WEST SUSSEX COUNTY COUNCIL CONSULTATION

TO:	Arun District Council FAO: Mr Michael Eastham
FROM:	Highways, WSCC
DATE:	12/11/2018
LOCATION:	Quiet Waters Roundstone Lane Angmering BN16 4AX
SUBJECT:	A/82/18/DOC Approval of details reserved by condition imposed under A/132/17/OUT relating to conditions 5-details of materials & finishes of buildings, surfaces for roads/footpaths, means of enclosure & parking of vehicles, 6-surface water drainage, 7-SuDS details, 10-landscape & layout, 11-refuse & recycling bins, 12-car, motorcycle & cycle parking, 13-location of fire hydrants, 14-decentralised & renewable or low carbon energy source, 16-covered & secured cycle parking & 27-noise levels.
DATE OF SITE VISIT:	N/A
RECOMMENDATION:	☒ Advice ☐ Objection ☐ Modification ☐ No Objection ☐ More Information ☐ Refusal
S106 CONTRIBUTION TOTAL:	N/A

West Sussex County Council as Highway Authority has been consulted upon the discharge of condition applications in relation to application A/132/17/OUT for 30 dwellings. These comments are in addition to previously made comments by the Highway Authority in June 2018 and are as a result of a revised internal layout (Proposed Site Layout Drawing Number Ang101

Drawing Title:
Proposed Site Layout

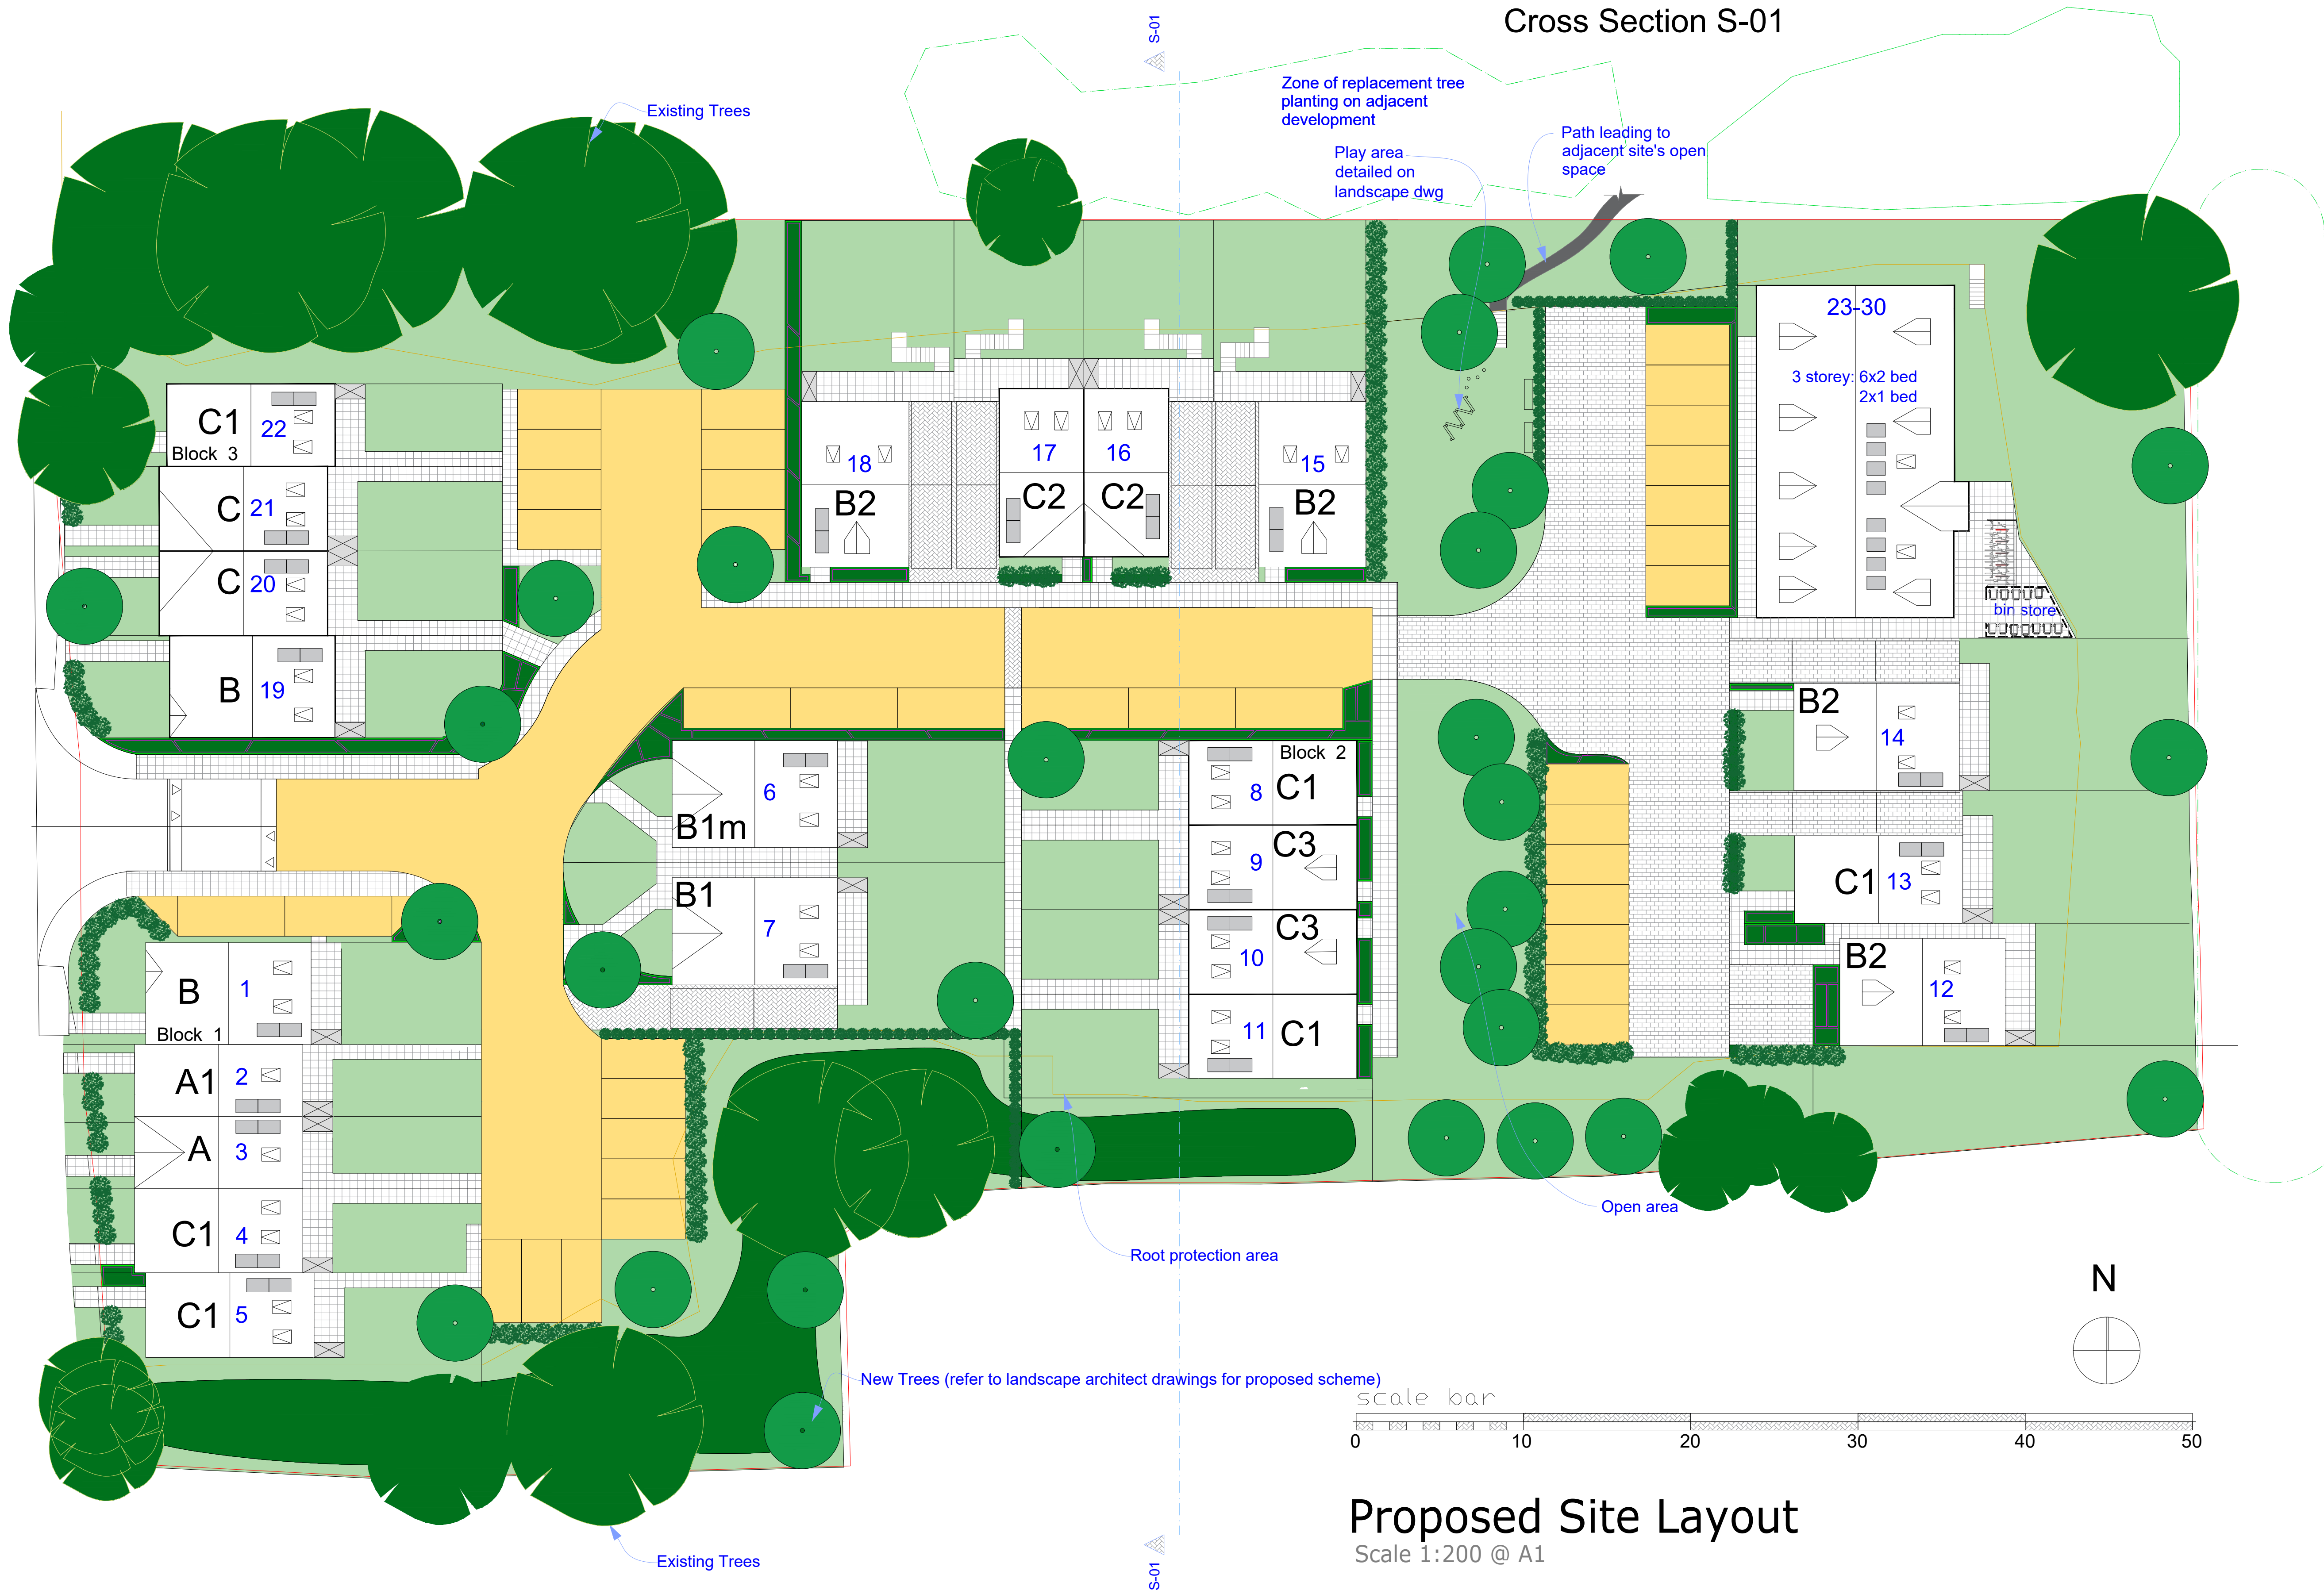
- **Condition 12 Parking Arrangements** – The applicant has reduced the overall car parking provision from 60 to 50 spaces. The reduction and revised layout in spaces is considered to have a less car dominated street scene. The overall car parking provision is deemed acceptable and not considered to cause significant overspill car parking which would warrant a reason for refusal. The proposed layout of the car parking spaces is not considered to pose any safety issues. Therefore the Highway Authority considers that the details for parking are acceptable and has no objections to the approval of condition 12.

- **Condition 16 Cycle parking** – the applicant is proposing a cycle store in the rear gardens of each of the house and a communal bike store located to the rear of the flats (plots 28-30). The design and dimensions of both of these types of stores are acceptable.

Drawing Title:
Proposed Materials Layout

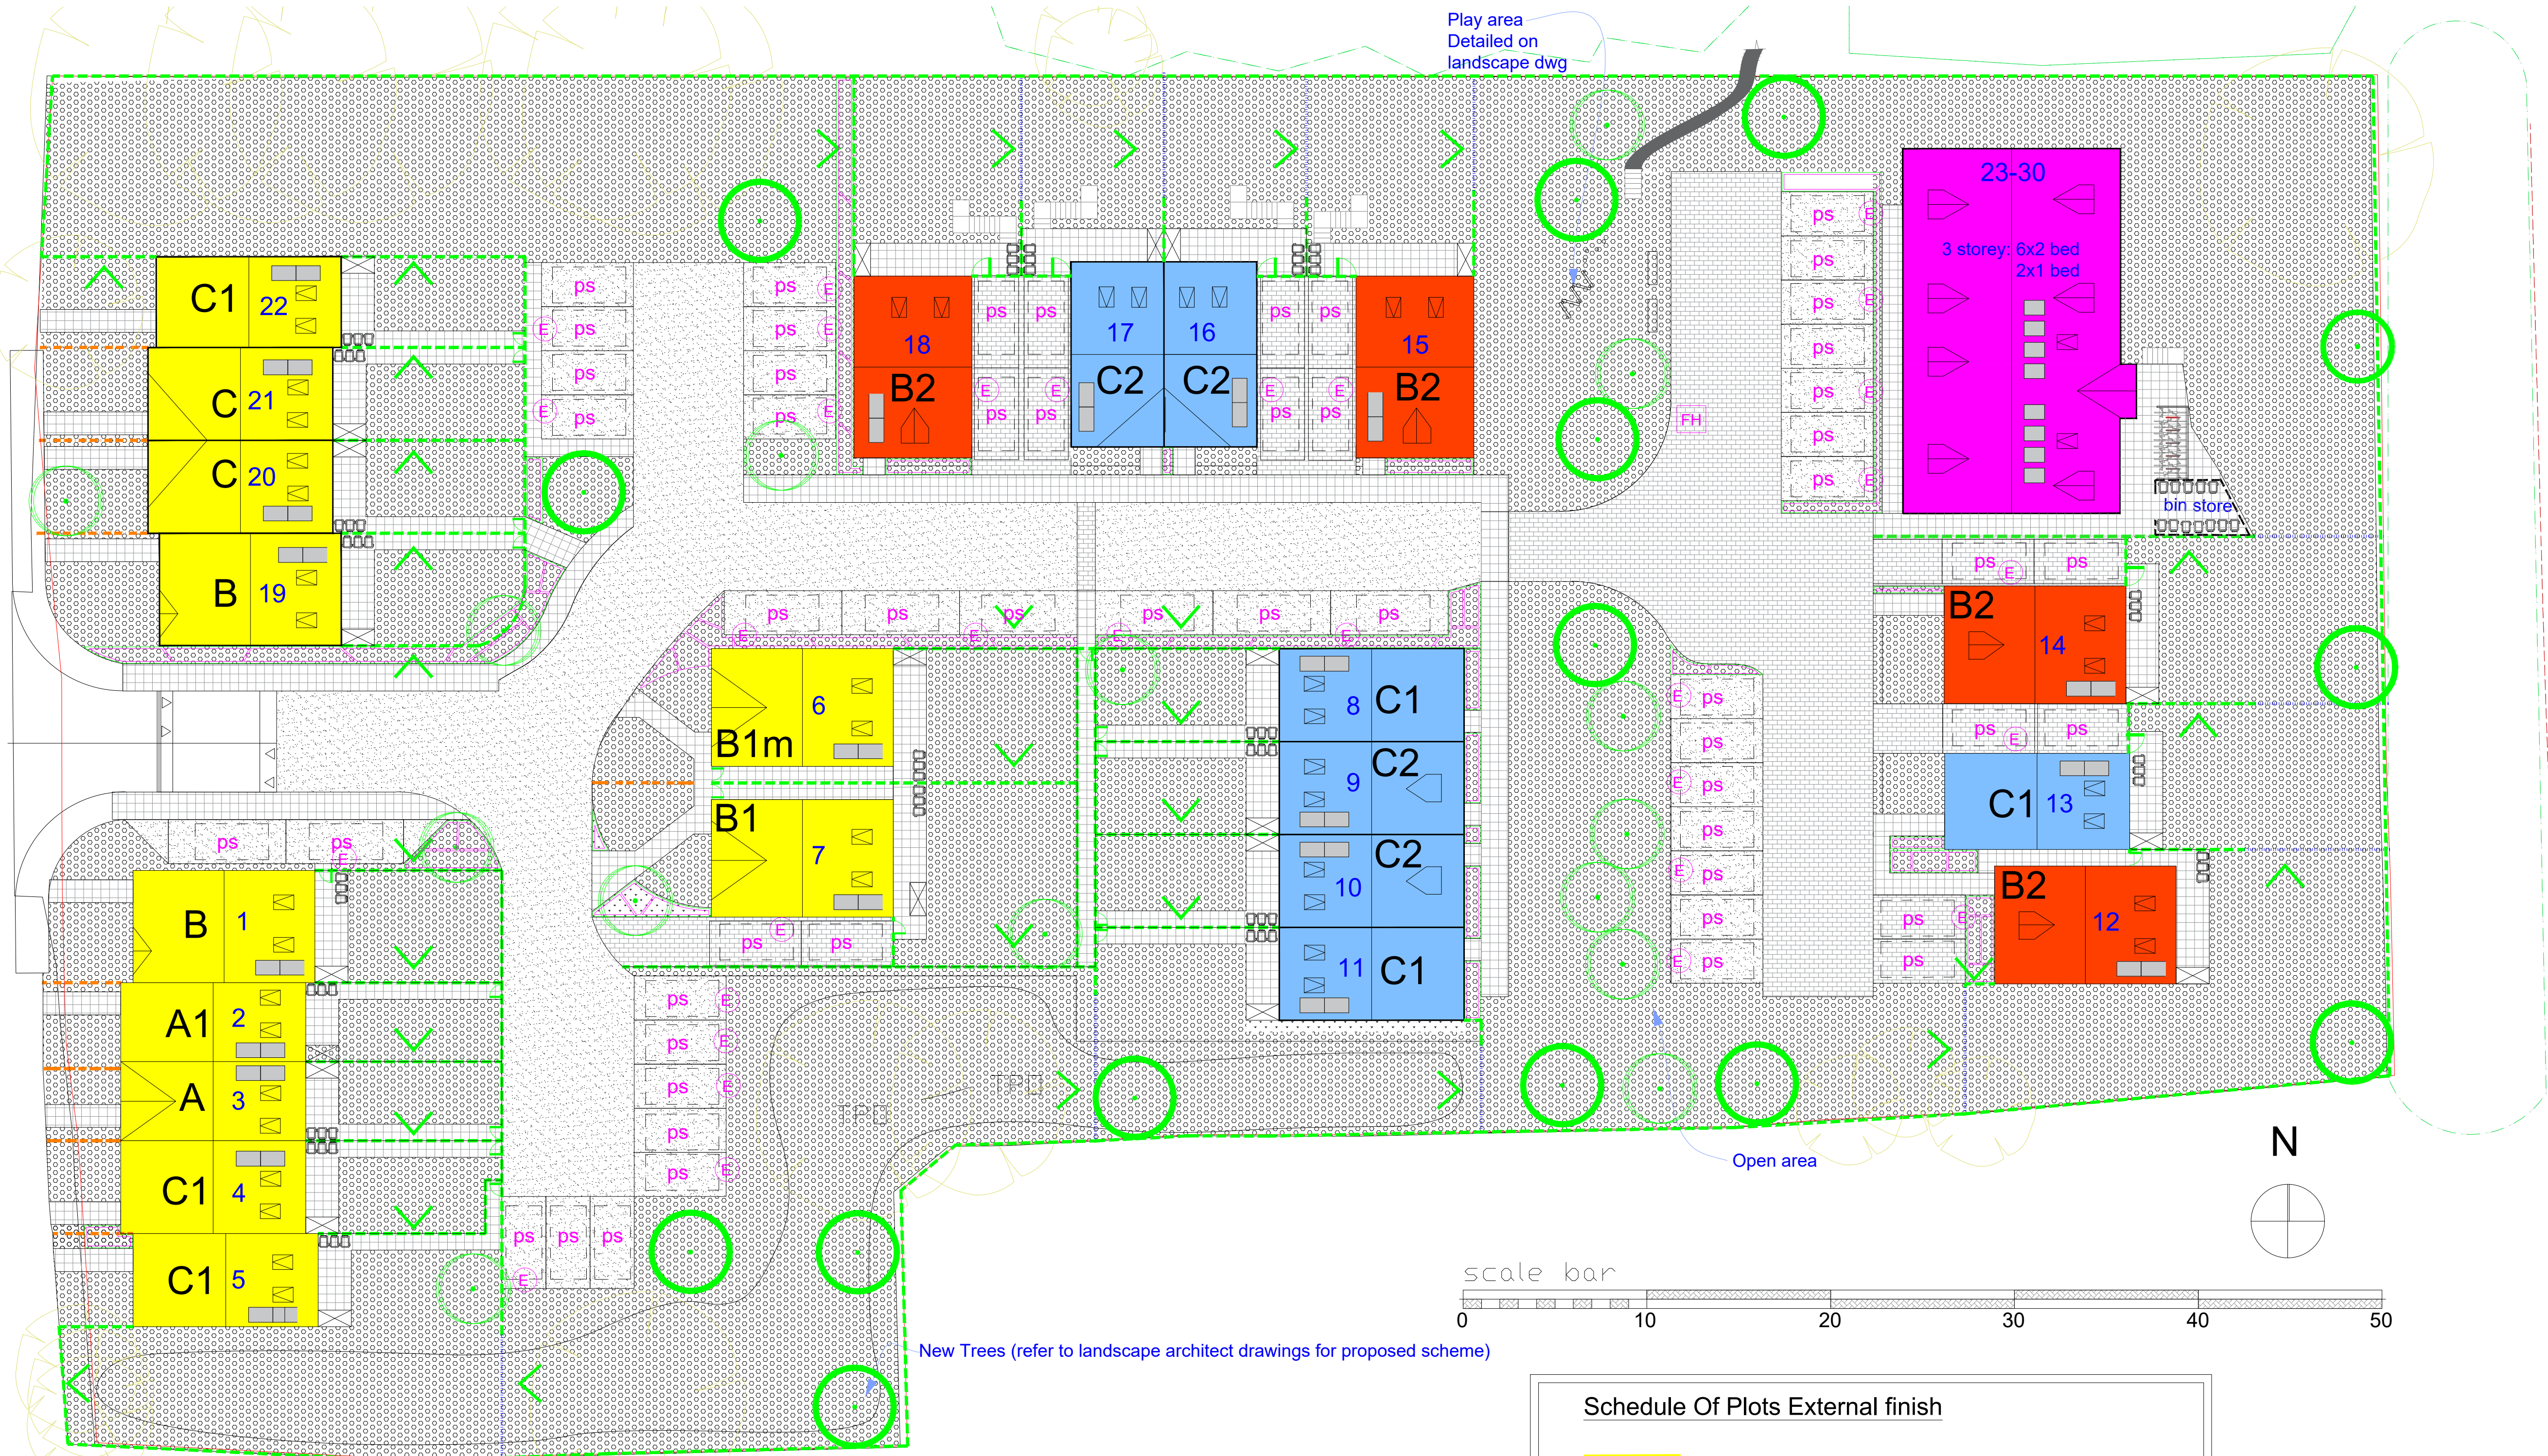
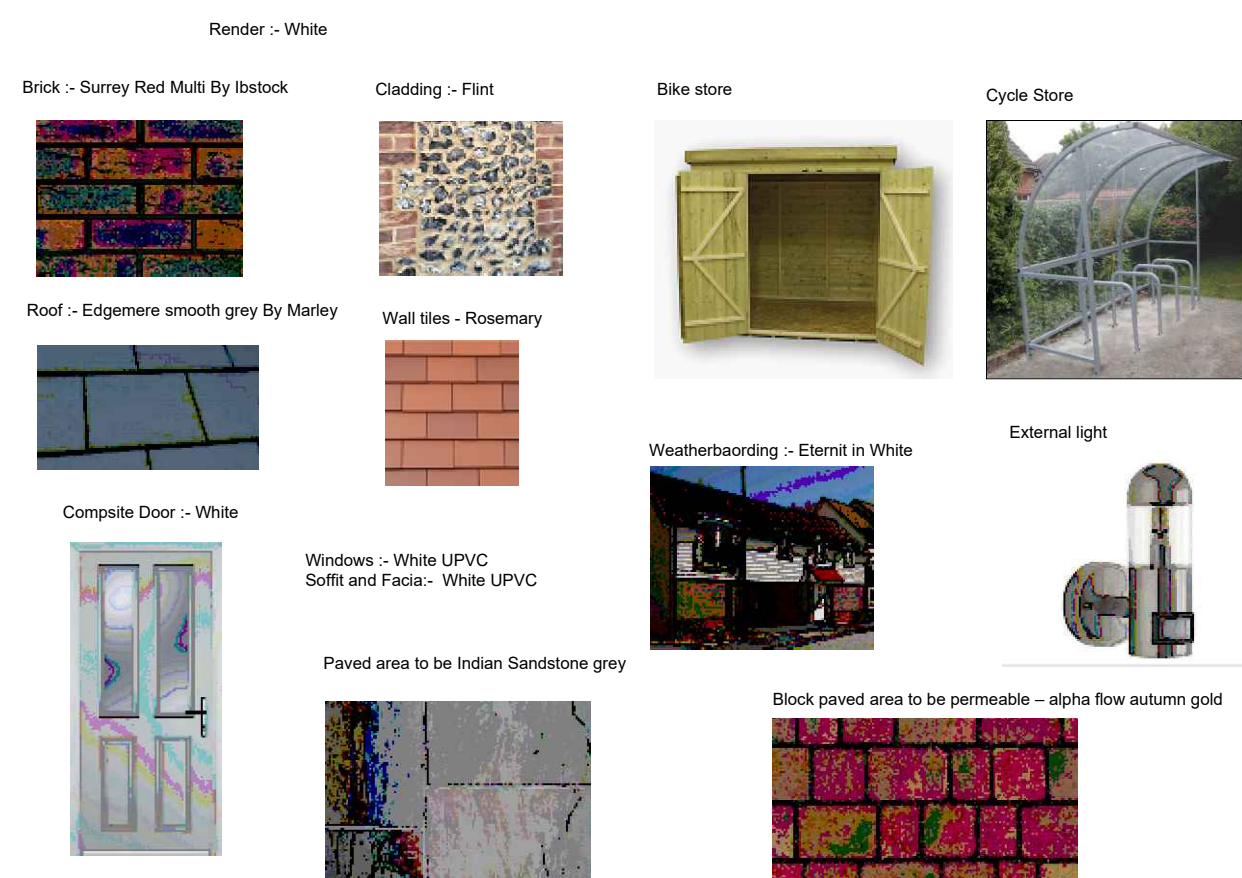
- **Condition 5 surface materials for roads and footpaths** – the Highway Authority does not wish to make any additional comments to those already made in their comments dated 28/06/2018. The Highway Authority has no objections to the discharge of condition 5.
